**WEST SUSSEX COUNTY COUNCIL
COUNTY HIGHWAYS CONSULTATION RESPONSE**

SUBJECT: FG/22/18/DOC - Application for approval of details reserved by conditions imposed under planning permission FG/37/17/PL relating to condition No. 3 (Schedule of materials), 4 (Surface water drainage), 6 (Construction Management Plan) & 8 (Landscaping scheme).

Onslow Caravan Park, Onslow Drive, Ferring, West Sussex, BN12 5RX

DWG. TITLE:	LANDSCAPE SCHEME	DWG. No:	037-LS01-02	Green
DATE:	10-9-17	PROJECT:	NEW STORAGE BARN	
Rev. No:	A	CLIENT:	ONSLOW CARAVAN PARK	
SCALE:	Green Landscape Design Worthing, West Sussex, BN11 1BQ GreenLD.co.uk Tel: 078 85 85 20 30			
				Landscape Design

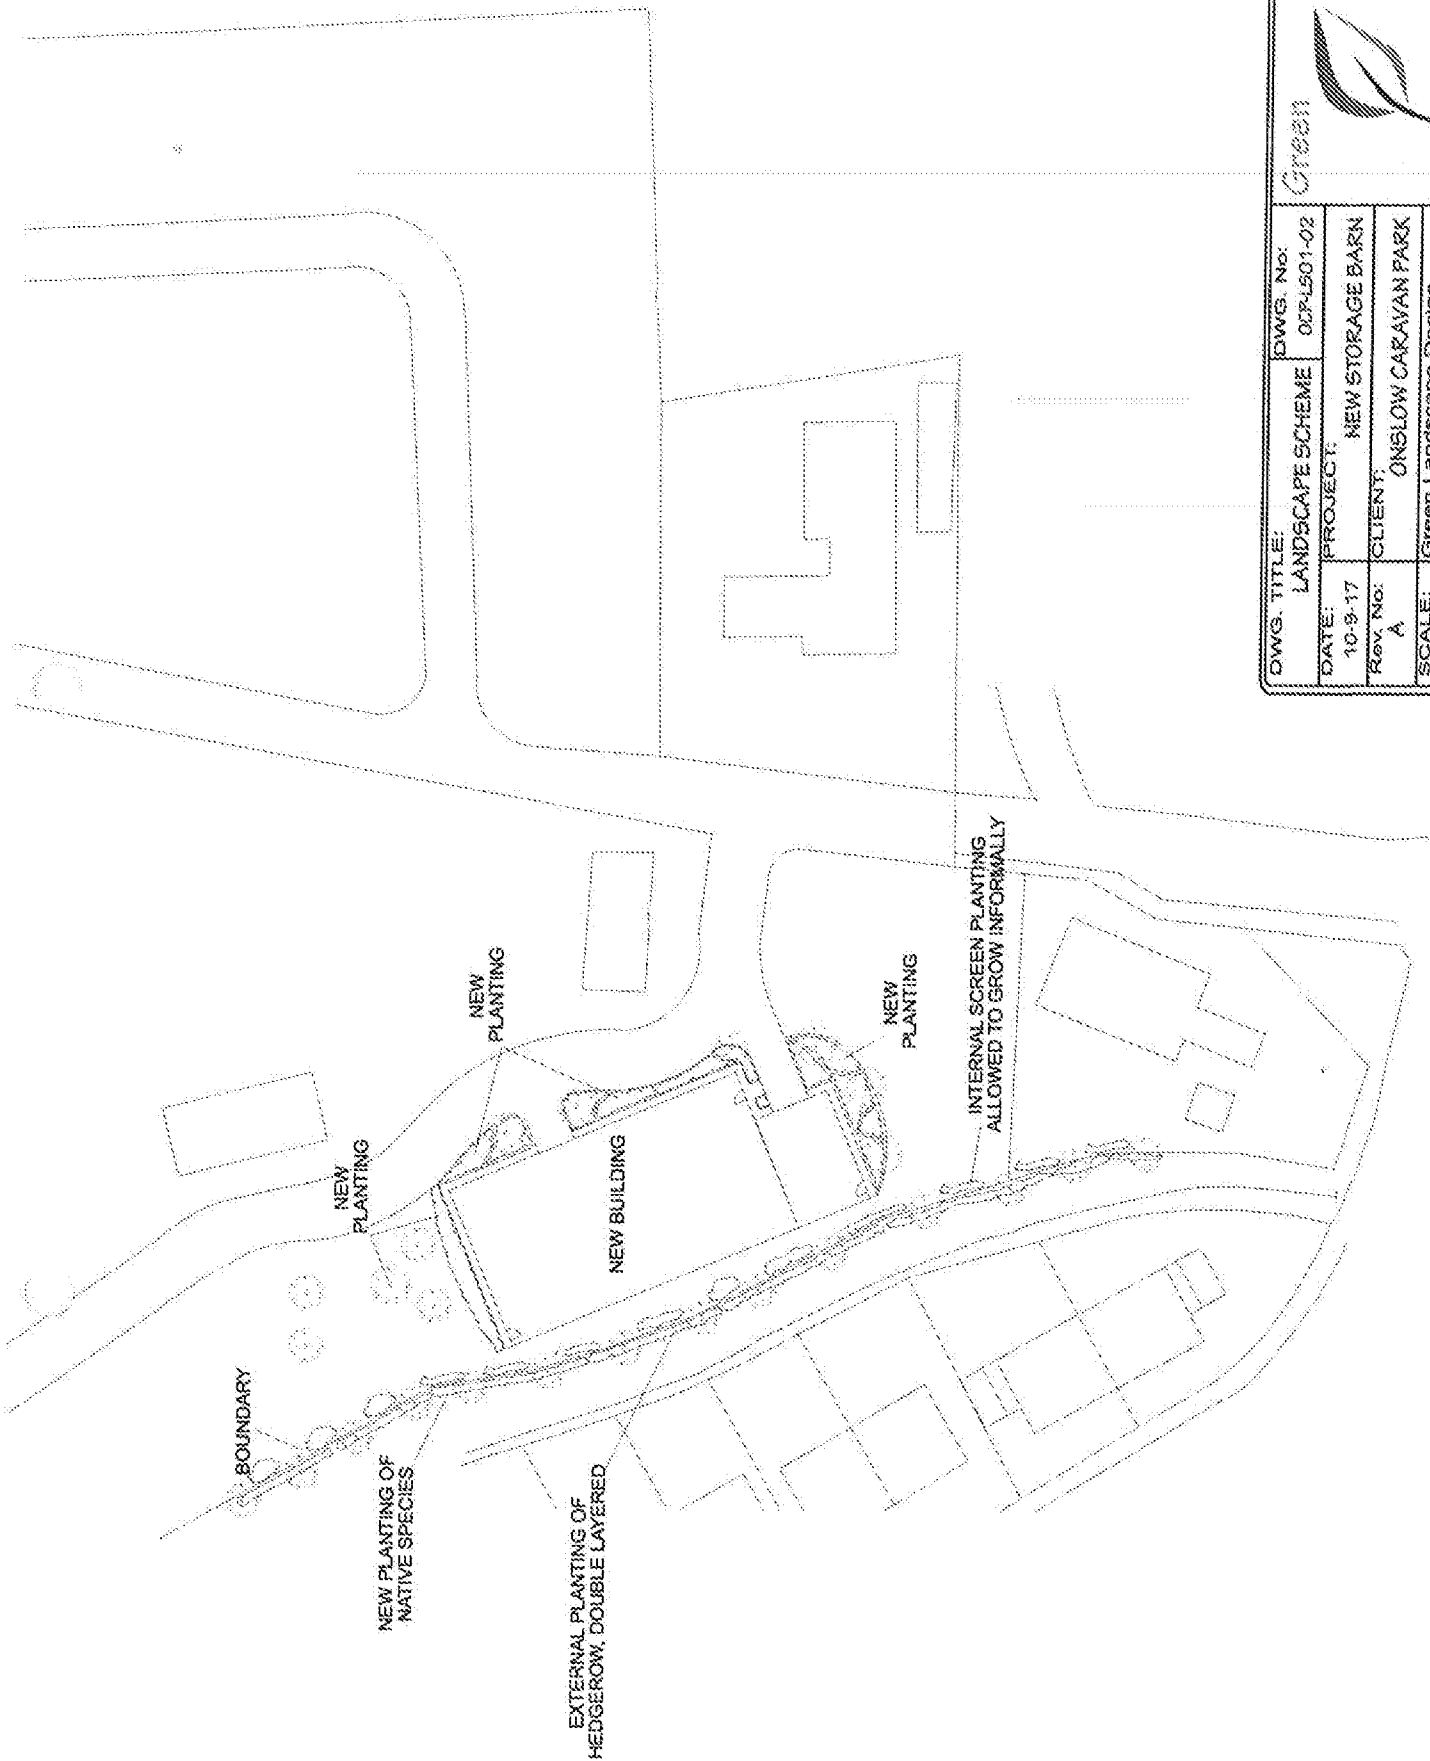
The proposed new building will not itself affect public footpath 2114_1, which runs immediately south of the caravan park. However, the proposed landscaping could, if planted incorrectly or left un-managed in future, have a detrimental impact on path users' safety, convenience and enjoyment of the path if the hedge is allowed to encroach into the width of the public footpath. Arun District Council must condition any consent such that the proposed planting must be planted so that when the hedge has become established it will not come closer to the path than any current hedging or fence; failure to ensure this will result in encroachment into the highway, which is an offence. The applicant is advised of his on-going duty to ensure the footpath is not obstructed.

After review of the Landscaping Scheme no highway concerns would be raised.

I do note that the southern boundary of the site runs adjacent to F.P 2114_1 and the landscaping will abut this boundary. I have therefore raised this application with WSCC Public Rights of way who may provide comments in due course.
